**From:** Nelson, Jennifer L (DFW) <Jennifer.Nelson@dfw.wa.gov>  
**Sent:** Wednesday, February 28, 2018 10:43 AM  
**To:** Lindsey Ozbolt; White, Lori (ECY); Kirsten Sackett (sackettk@ci.ellensburg.wa.us); Craig Jones (jonesc@ci.ellensburg.wa.us); Karen Hodges  
**Cc:** Mark Cook; John Marvin  
**Subject:** RE: PD-16-00001 Commons At Dry Creek - Wetland Reconnaissance  
**Attachments:** Aug 2017 WDFW comments MDJ updated rezone and Long plat.pdf; WDFW\_comments and figures\_MDJ\_rezone\_and\_long\_plat\_May2017.pdf

**From:** Lindsey Ozbolt [mailto:lindsey.ozbolt@co.kittitas.wa.us]  
**Sent:** Thursday, February 15, 2018 9:48 AM  
**To:** White, Lori (ECY) <lowh461@ECY.WA.GOV>; Nelson, Jennifer L (DFW) <Jennifer.Nelson@dfw.wa.gov>; Kirsten Sackett (sackettk@ci.ellensburg.wa.us) <sackettk@ci.ellensburg.wa.us>; Craig Jones (jonesc@ci.ellensburg.wa.us) <jonesc@ci.ellensburg.wa.us>; Karen Hodges <karen.hodges@co.kittitas.wa.us>  
**Cc:** Mark Cook <mark.cook@co.kittitas.wa.us>  
**Subject:** PD-16-00001 Commons At Dry Creek - Wetland Reconnaissance

**RE: WDFW comments on PD-16-00001 and LP-17-00004 MDJ Rezone and Long Plat near Currier Creek (Commons at Dry Creek)**

**RE: WDFW comme

SHEET CONTENTS
SITE PLAN

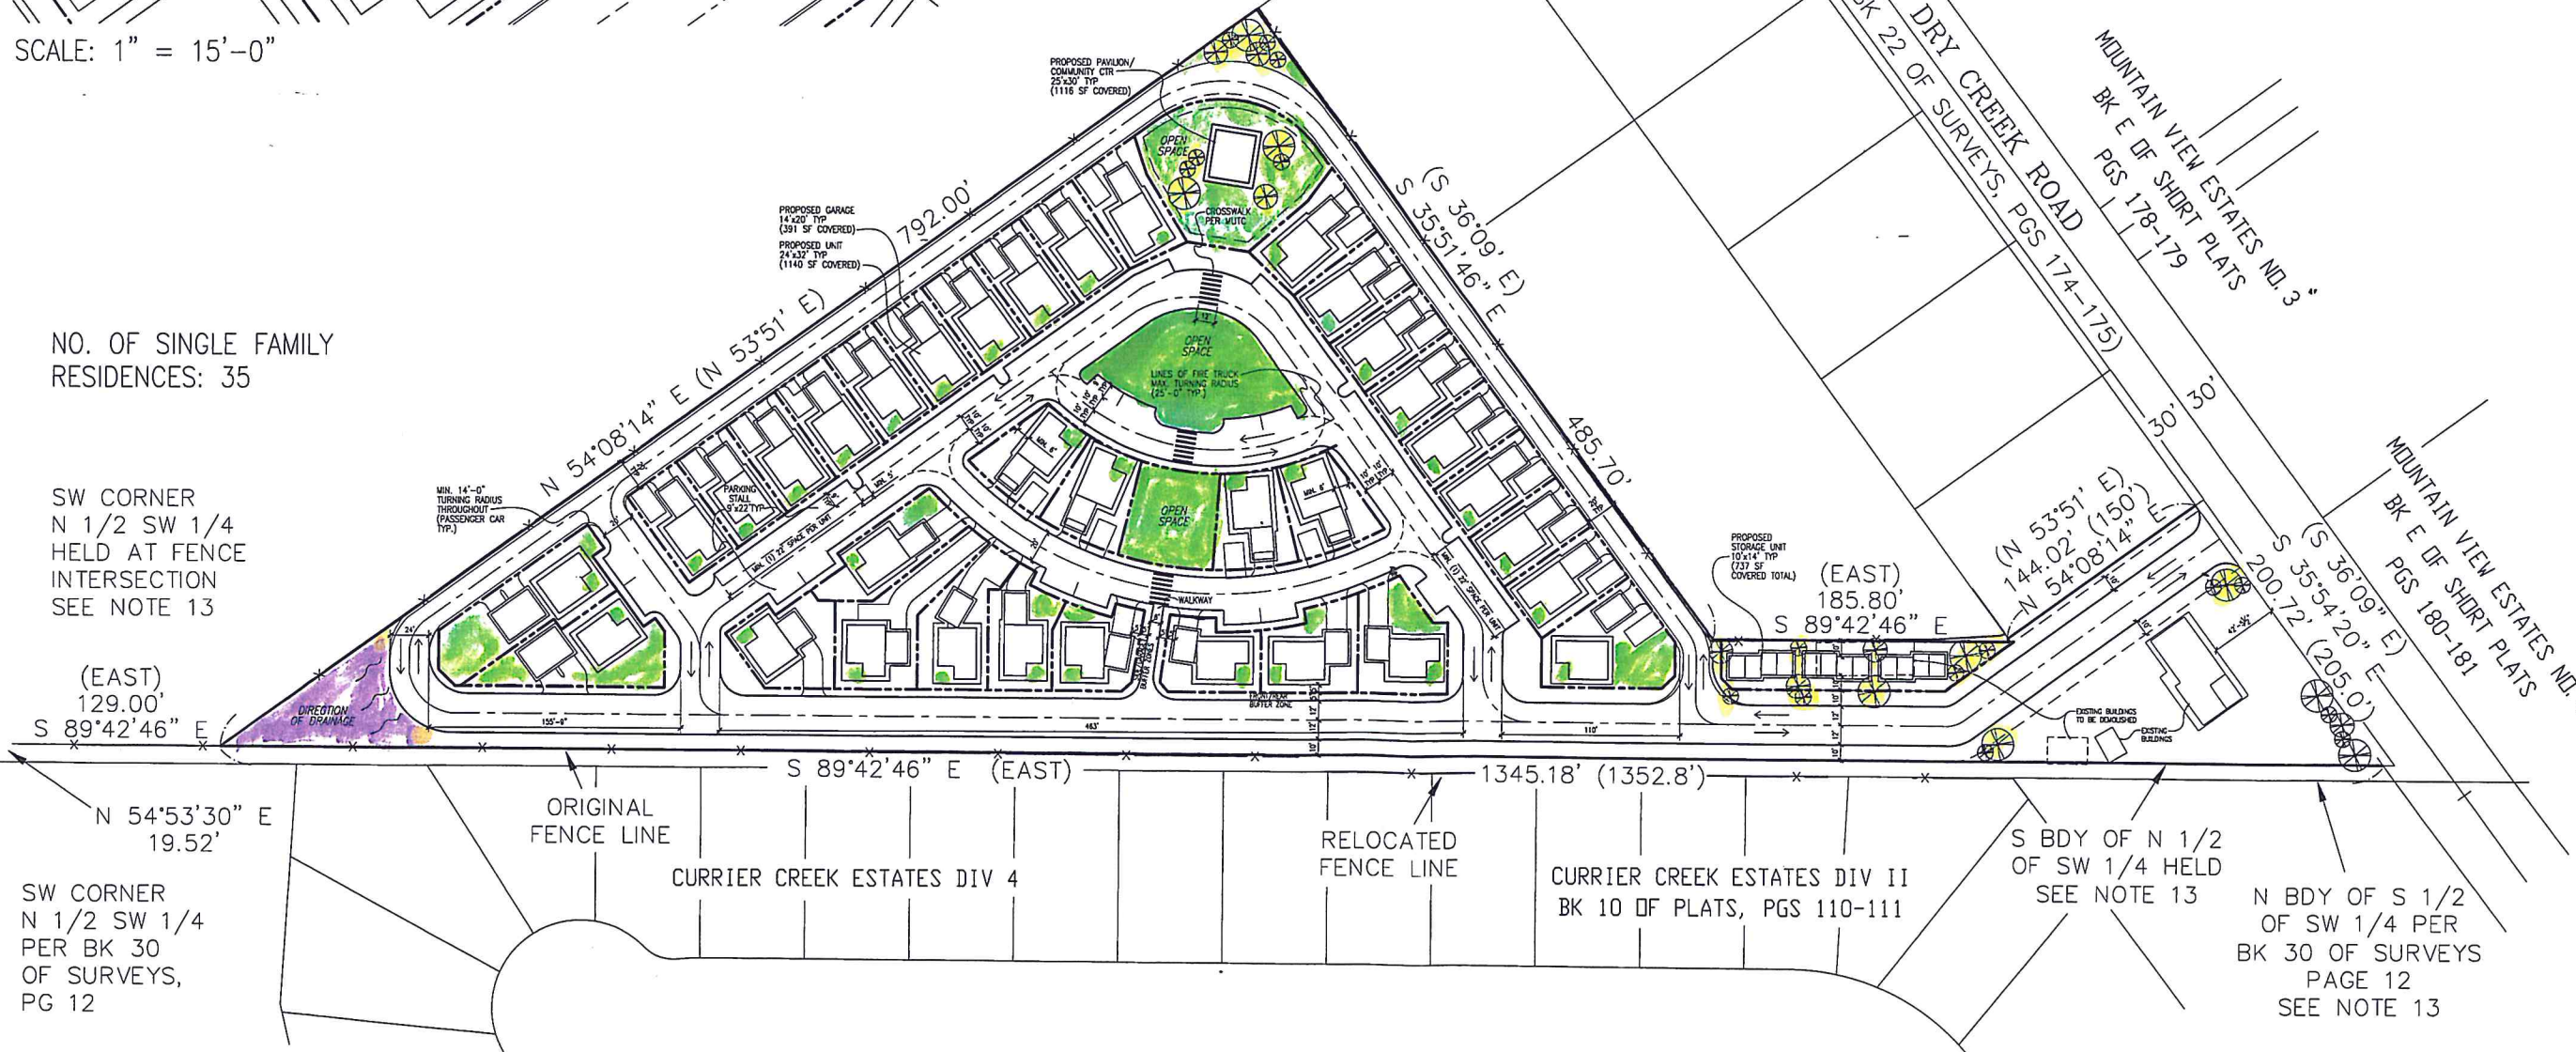
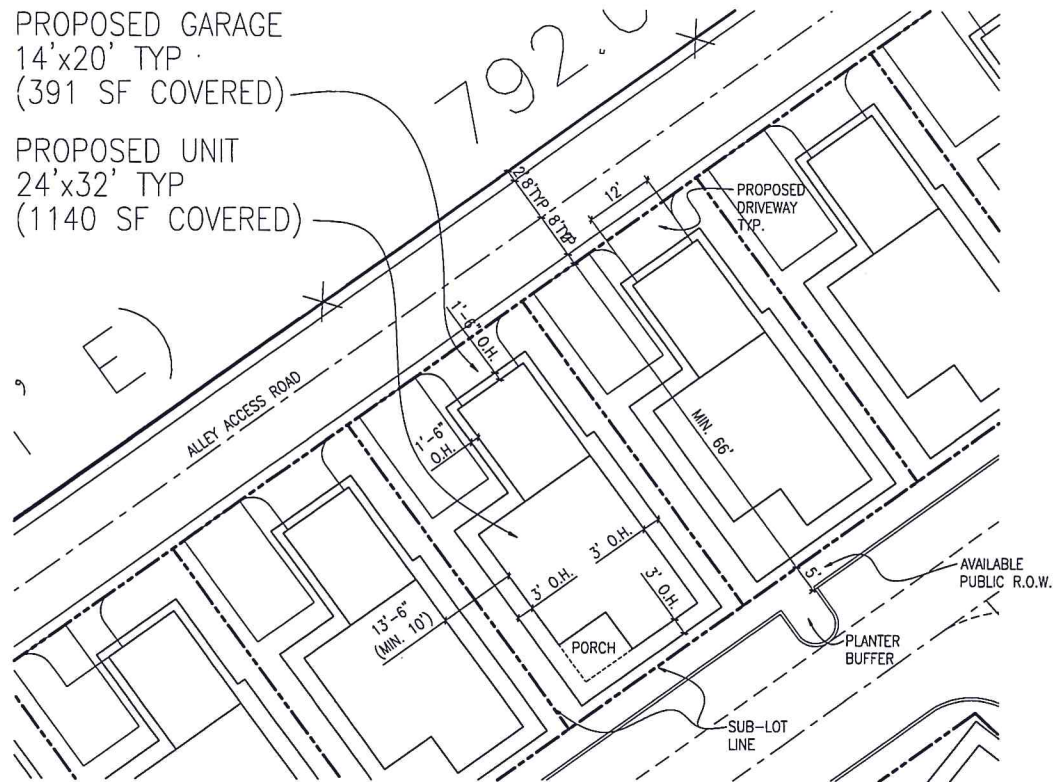
The revised and updated proposed rezone and long plat (PD-16-00001 and LP-17-00004 MDJ) to create 34 new homes and associated infrastructure still does not address the probable significant environmental impacts associated with its approval and construction. Approval of this rezone and long plat as designed will result in additional homes and streets flooding and the desire to confine flood flows. Flood control features would damage critical areas and the fish and wildlife that depend on wetlands, floodplains, and the Currier Creek corridor. The proponents of this development and Kittitas County should demonstrate that there is no net loss of flood conveyance or storage and that the proposed development will not result in increased velocities that become more damaging to infrastructure or fish habitat as it reenters Currier Creek.

With the information provided to us for review, WDFW believes the proposed development will likely result in the new homes being flooded and increased flood risks to surrounding properties due to reduced floodplain capacity and impacts to wetland habitat. In light of the presence of surface water and potential for floodplain

- Provide the wetland report referenced in the SEPA documents for public review and comment.
- Require a detailed study to determine whether or not the proposed development will increase flood risks to surrounding property owners and if the proposed new structures will be flooded. This study should also detail how flows (quantities and velocities) may be altered as they relate to Currier Creek and the fish and wildlife habitat associated with it.
- Require a detailed study to determine if there is a loss of floodplain conveyance and storage. Provide appropriate mitigation if warranted.
- If warranted based upon information from the studies mentioned above, reduce the lot density to allow for more floodplain storage. This may include enhancing wetland habitat within the proposed open space areas.

This is the proposed  
rezone and long plat for  
MDJ-Cottage  
Grove/Currier Heights.  
Currier Creek Estates is  
located immediately  
south of this  
development and  
homes along Creeks  
Edge Way already  
experience flooding.
